From: Simon Davis
Sent: 23 July 2020 18:54
To: Chris Brake [REDACTED]
Cc: Megan Hodges [REDACTED]
Subject: AL/46/20/PL Wings Nursery

I have now had the comments of our Group Head of Planning and have added these to my own comments such that I am now able to provide you with our assessment of the proposals set out under the following headings. Overall, we feel that the amount of development is too much and that a lesser amount would ensure that standards are met and prevent harm to existing adjoining neighbours. Our view is that there are too many issues on this to negotiate and we should be refusing this under delegated powers. However, you may alternatively wish to withdraw and discuss an amended layout with us prior to resubmitting?

9 LAYOUT - SITE PLAN

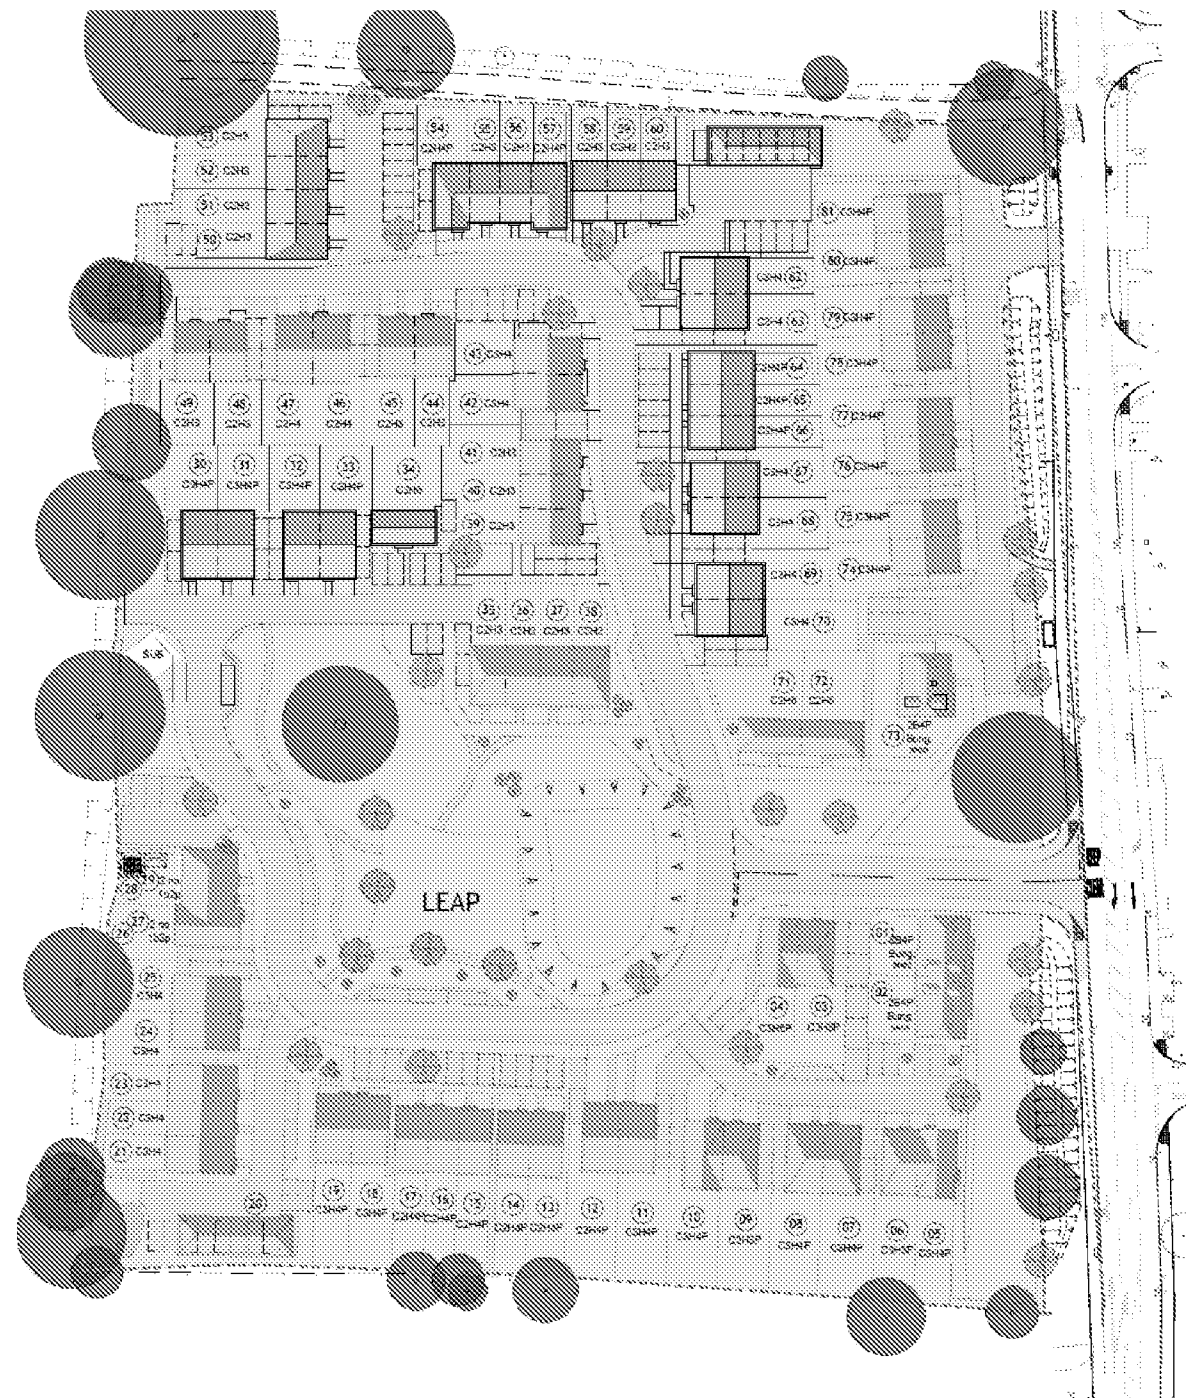
Unclear as to surveillance over strip of land W of plots 30 & 49

Unclear as to surveillance of land & pond in SW corner

Unclear as to surveillance of POS(?) in NE corner (N of plot 81)

Parking is remote (not on plot) for plots 20-23, 50, 54 – 63 & 72. This will result in on-street parking

Parking courts should only be considered as a last resort (e.g. plots 54-63) and if have to be provided then should have a frontage and landscaping

The two blocks (plots 54-57 & 58-60) are too close together

We are concerned over garden depths of plots 1 & 2, 57-60, 73 which are less than 9m so significantly below the 10.5m requirement as per emerging Arun Design Guide. There are others around the 10m mark. The two FF Flats (plots 26-29) should have balconies facing W or N as otherwise no amenity space. It is unclear as to the garden for FOG's (plots 20 & 61). If treated as flats, then should have a private patio area or balcony at the least.

Plots 40-42 & 71-72 look straight into adjacent rear gardens
FOG 20 would appear to be only around 11m from 2 storey Stockhearn House (neighbouring dwelling) to the south and this is not acceptable.

Semi-detached, flint feature detailing

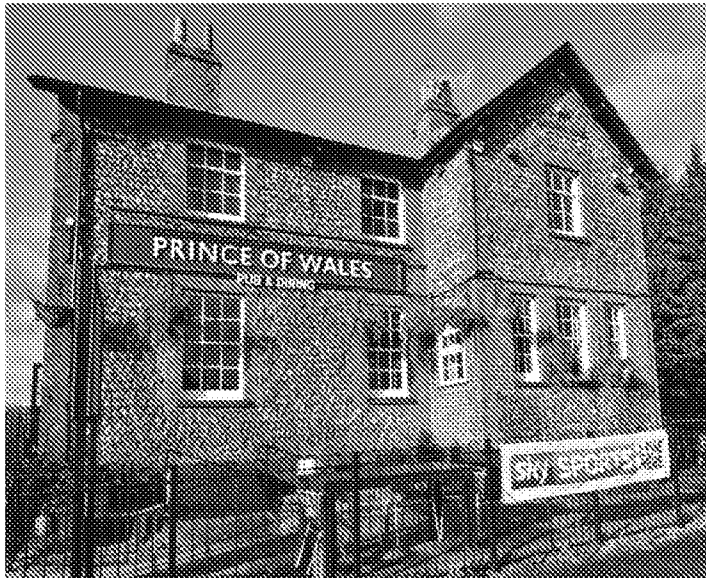
We are not sure if flint is appropriate to the setting – where are nearby flint examples?

The only 'design' on the plots to the frontage (74 – 81) is flint and there are no other examples of design features.
